Charlotte Storm Water
600 East Fourth Street
Charlotte, N C 28202-2844

Rezoning Petition Review

Rezoning Petition #: 20-194

Proposed Zoning: MUDD-O

SHEET
REZONING PLAN
RZ.01

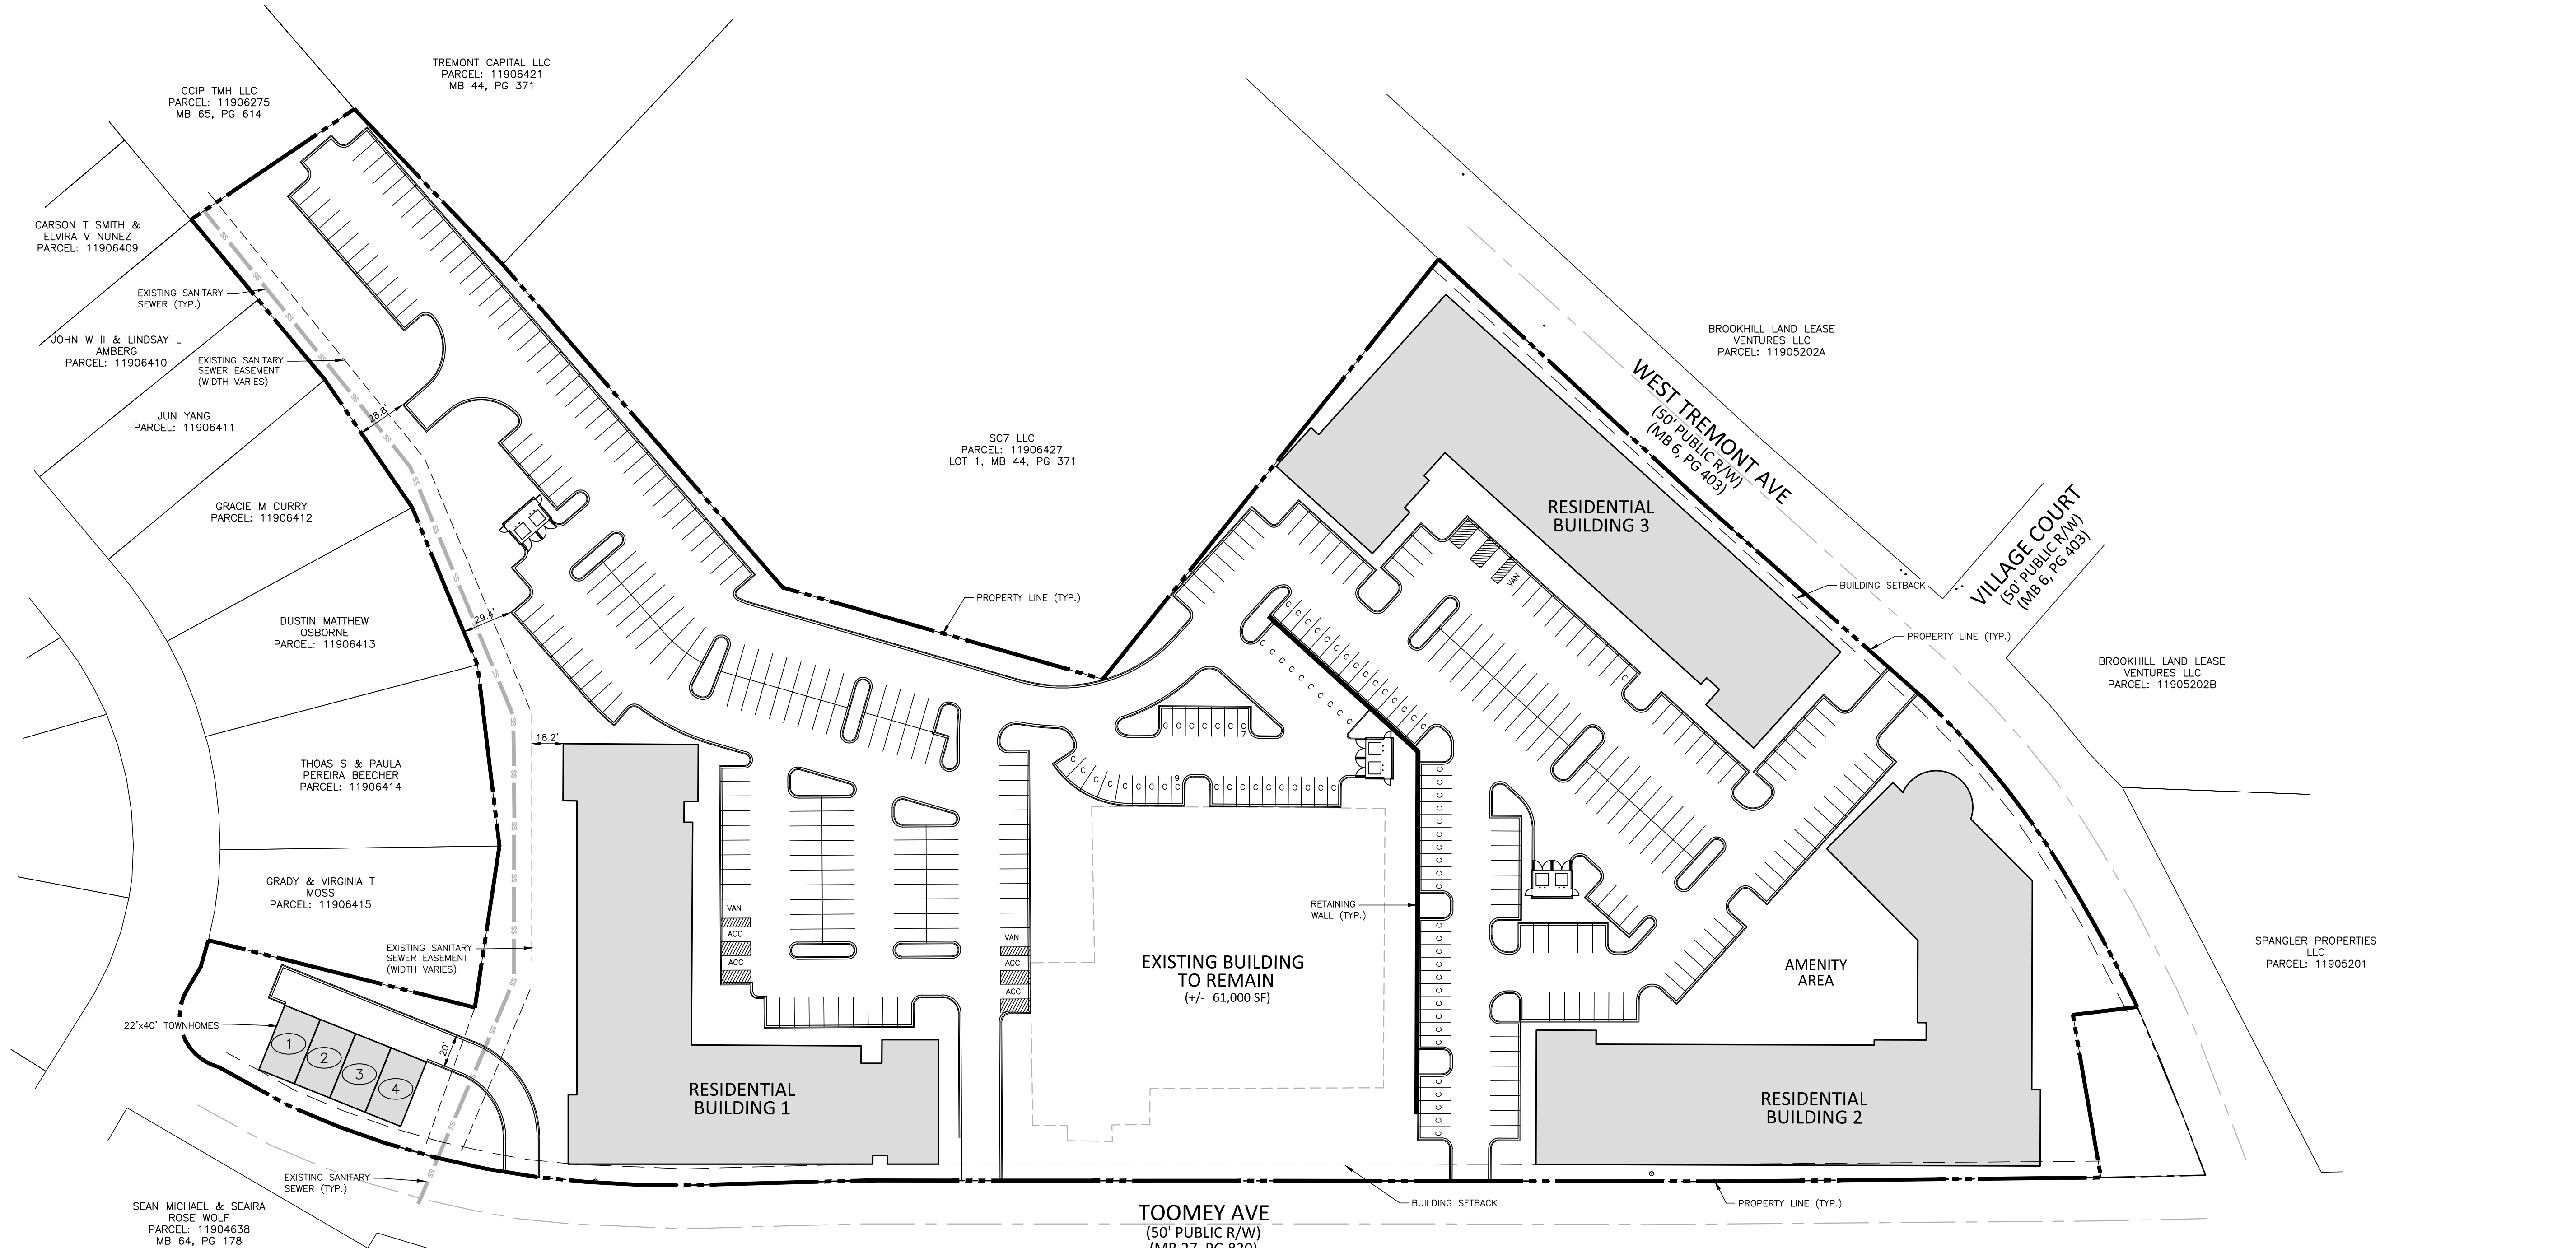
Recommendations Concerning Storm Water: Please note that City of Charlotte GIS indicates a stream channel feature through this site which may require a Post Construction Water Quality Buffer. Please note development within any SWIM/PCSO Buffer shall be coordinated with and subject to approval by Charlotte-Mecklenburg Storm Water Services and mitigated if required by City ordinance. Petitioner acknowledges intermittent/perennial stream delineation reports are subject to review and approval upon submission of development plans for permitting and are not approved with rezoning decisions.
